From: Carmichael Ian <Ian.Carmichael@thamesvalley.pnn.police.uk>
Sent: 09 April 2020 09:46
To: Linda Griffiths
Cc: Planning
Subject: Planning ref: 19/01037/REM (FURTHER AMENDMENTS). OS Parcels 6741 and 5426 West of Cricket Field and North of Wykham Lane Bodicote.

Planning ref: 19/01037/REM (FURTHER AMENDMENTS). OS Parcels 6741 and 5426 West of Cricket Field and North of Wykham Lane Bodicote.

Drawing Title
Enclosures Details 1 of 2

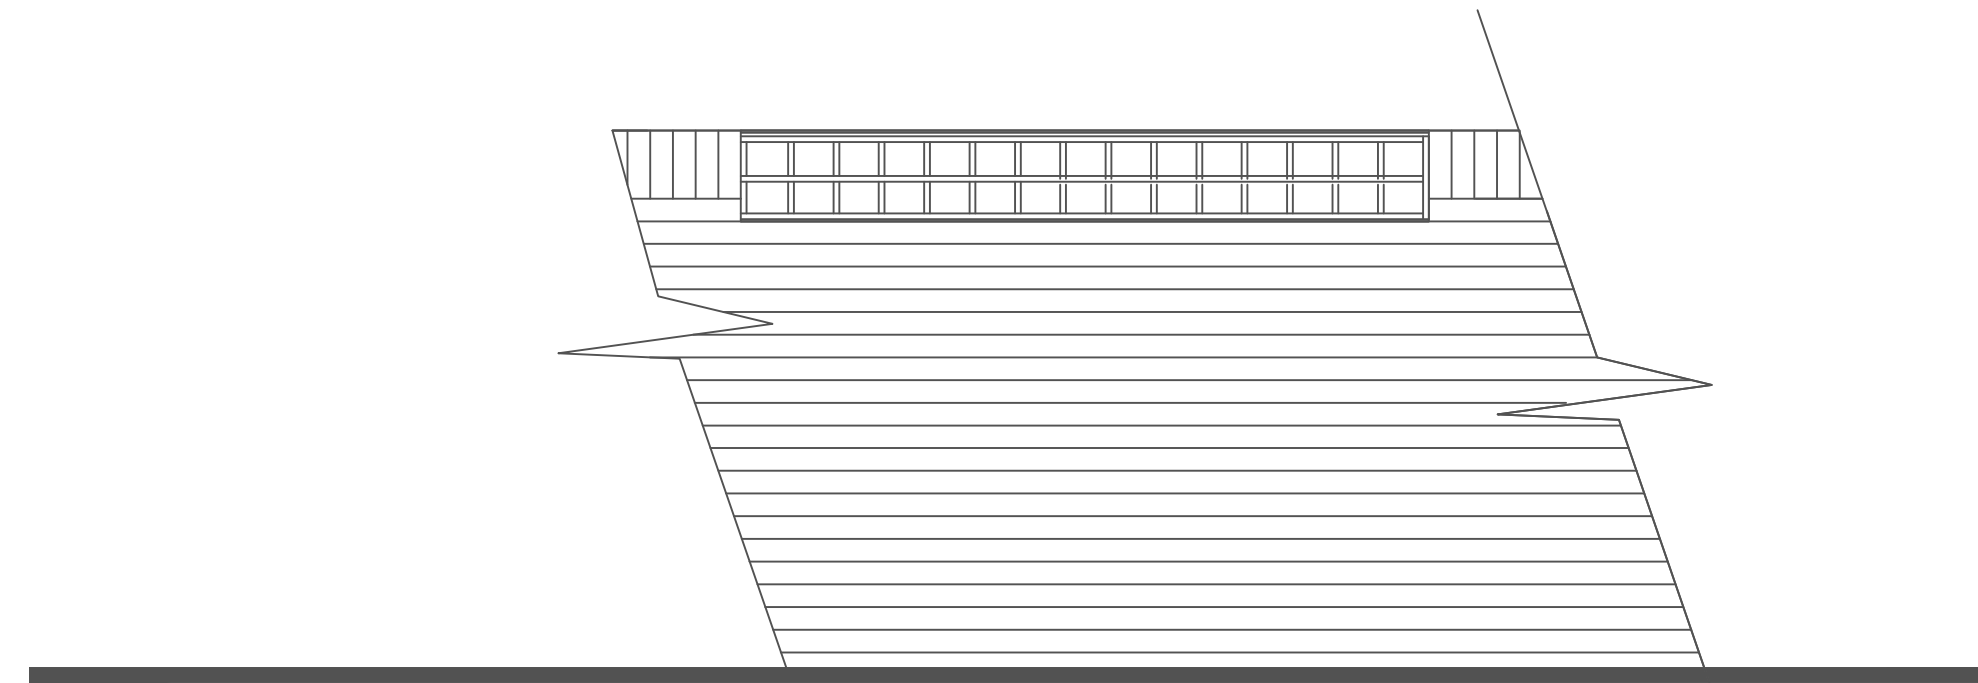
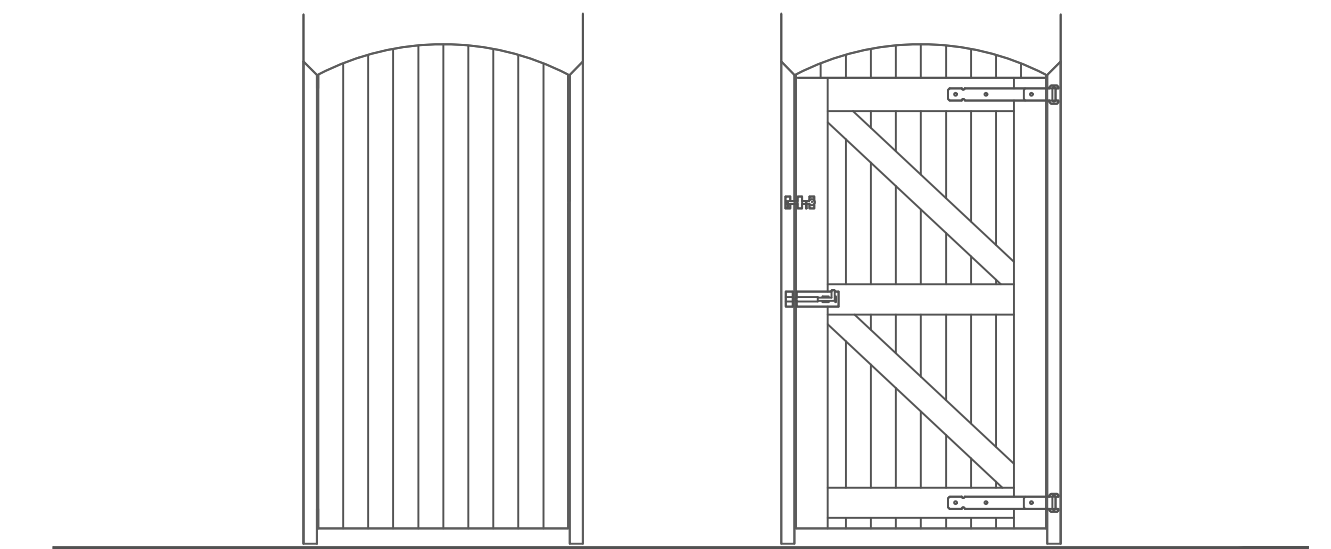
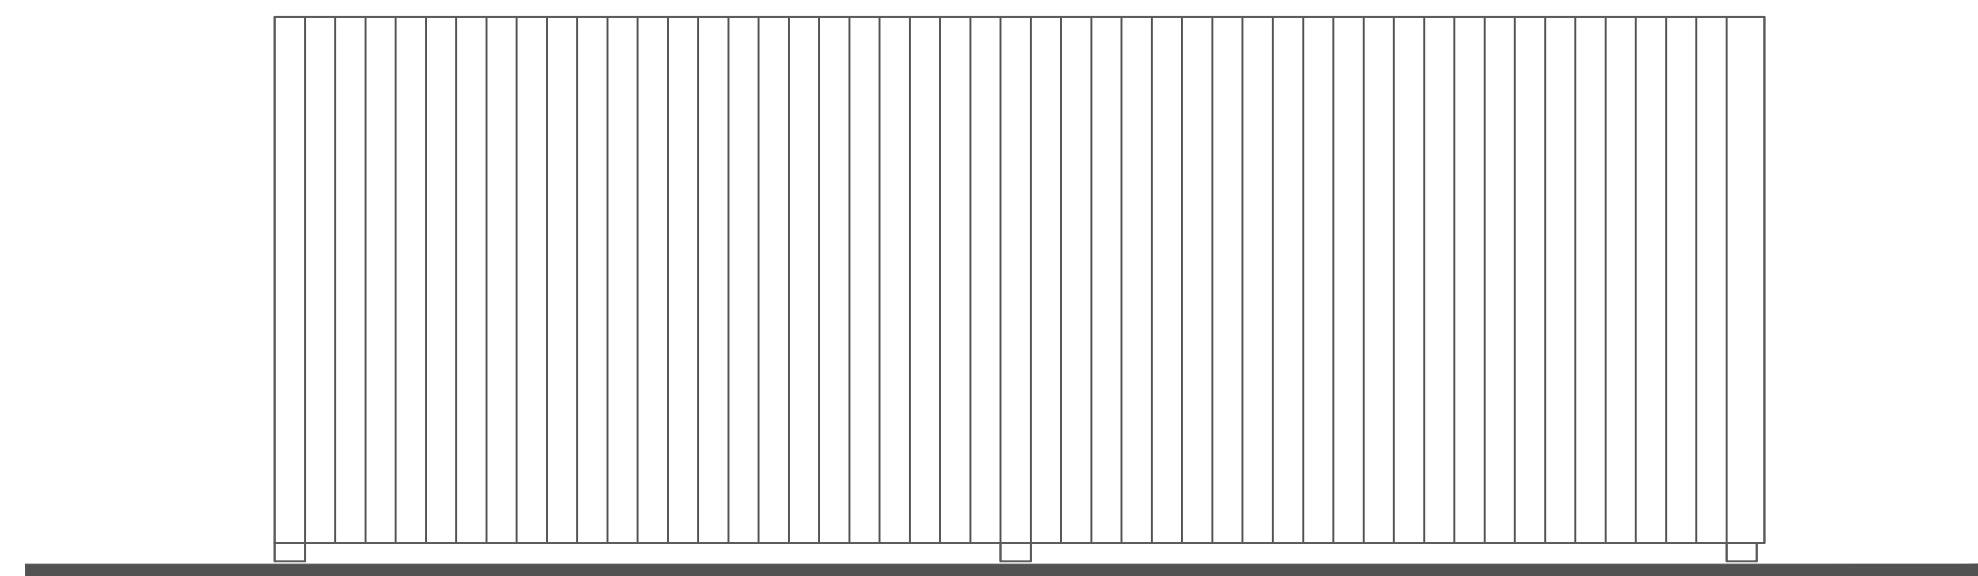
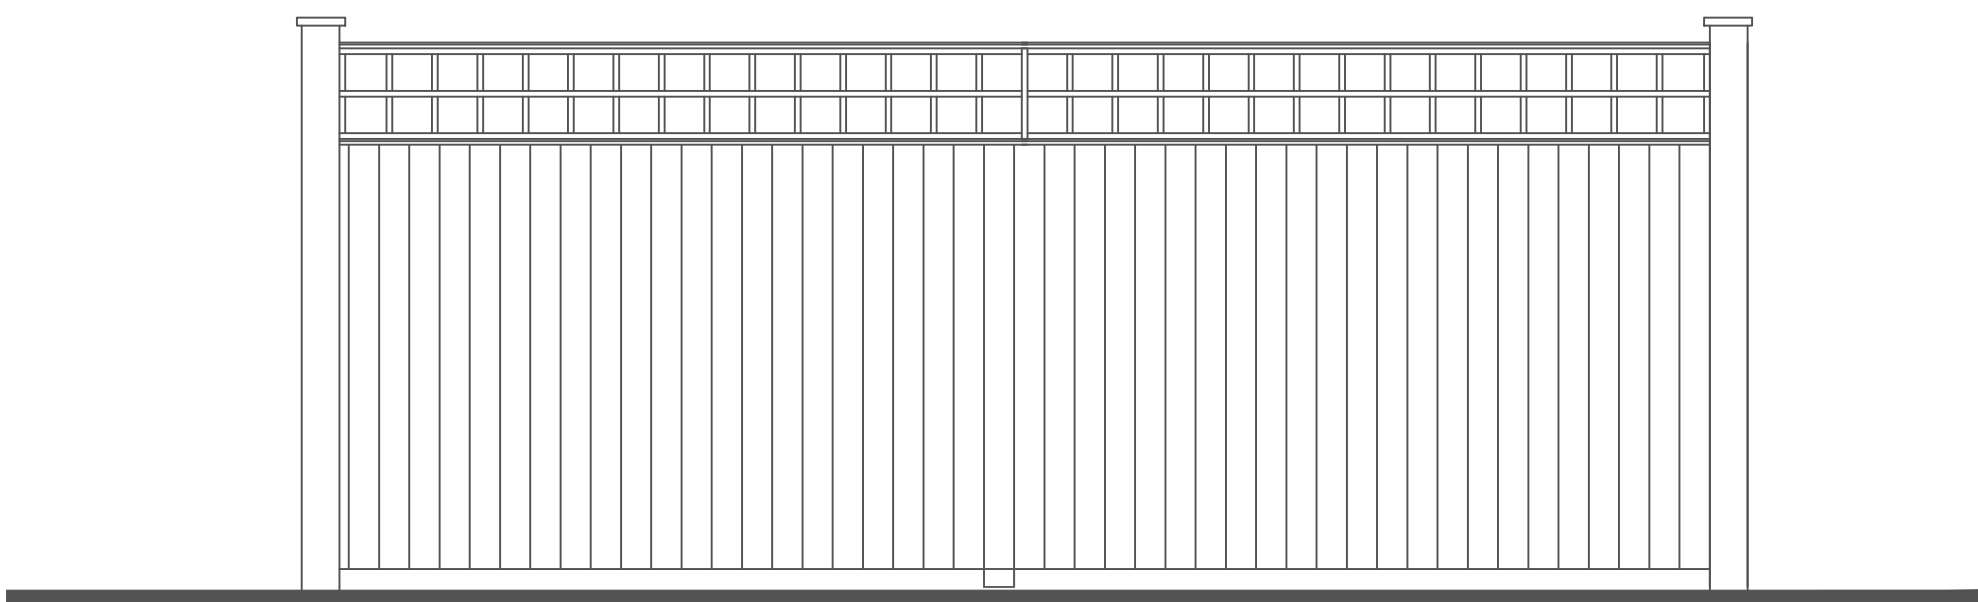
- Despite there now being more parking courts making additional rear gardens of dwellings vulnerable, advice on the specification of boundary treatments has not been taken on board.

- Where boundary treatments of private rear gardens abut public or semi-private space they should incorporate features that make them difficult to climb; trellis on fences, angled or rounded copings on walls etc. All access gates to rear gardens (including communal ones) should be; robust, of the same height as boundary treatments, self-closing, have anti-lift hinges and be key operated from both sides. Also, some gates to rear gardens are not provided as close to the front building line as possible, which creates problematic recesses. I would like to see them brought forward wherever possible. And, I note that the DAS states that 'Hit and miss' fencing will be used to provide oversight of parking to the rear of properties. However, the Enclosure Plan shows no such fencing. The proposed visually permeable treatment should be used where possible and appropriate.
